CITY OF PORTLAND

Permit Number: 051368

Proposed Project Description:
Change rafters rafter ties & joist construction to prefab rafters.

RE: 24' x 24' garage on 43 Bay St, Portland

# ROOF FRAMING

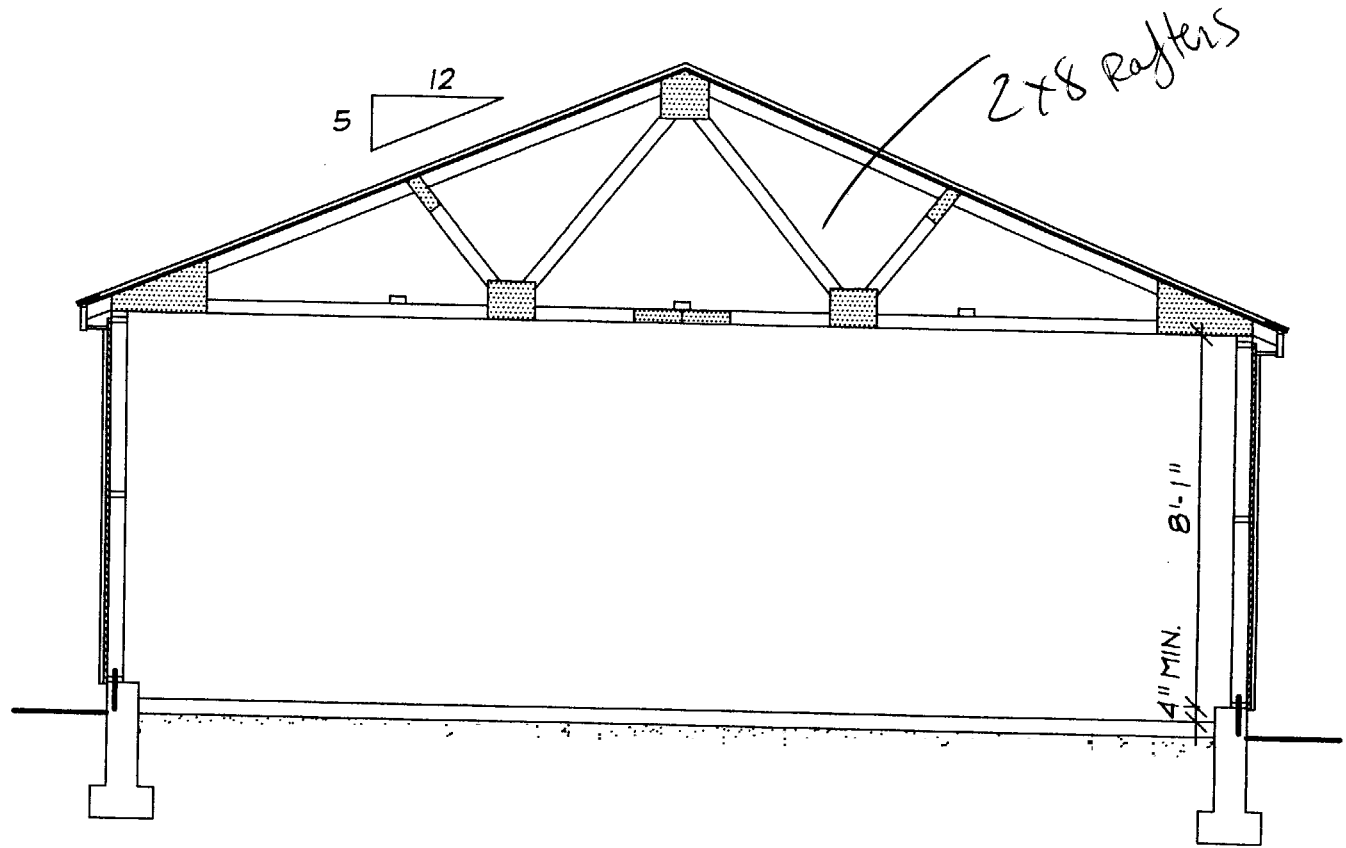
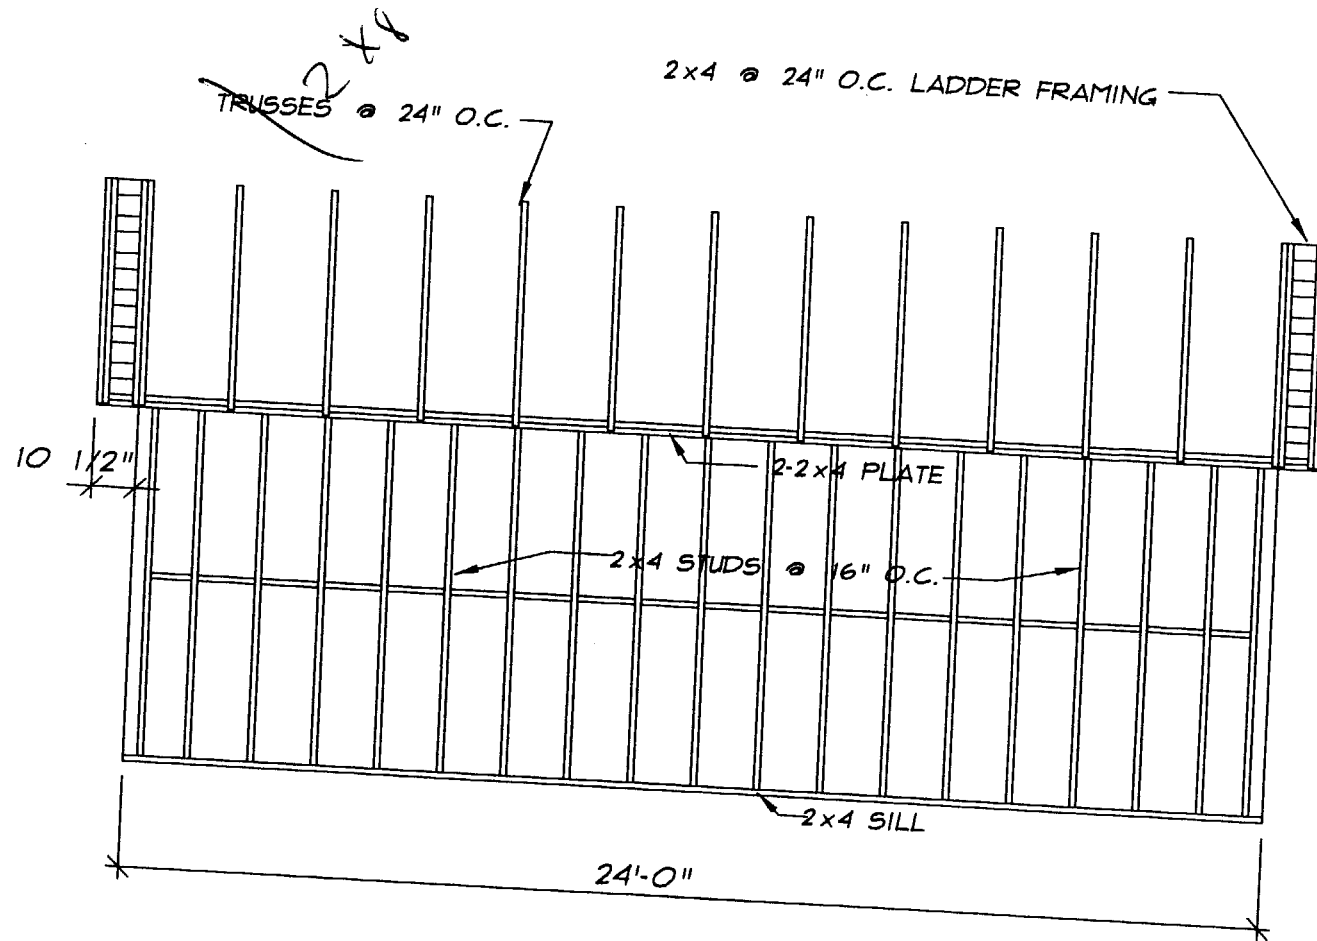
Rafters, rafter ties and joists are being changed to prefabricated trusses as detailed above. This change makes the lally column support and the center beam unnecessary. These items have been deleted from the above materials list and the trusses have been added.

Need Spec on Framing at Truss
for Stair opening
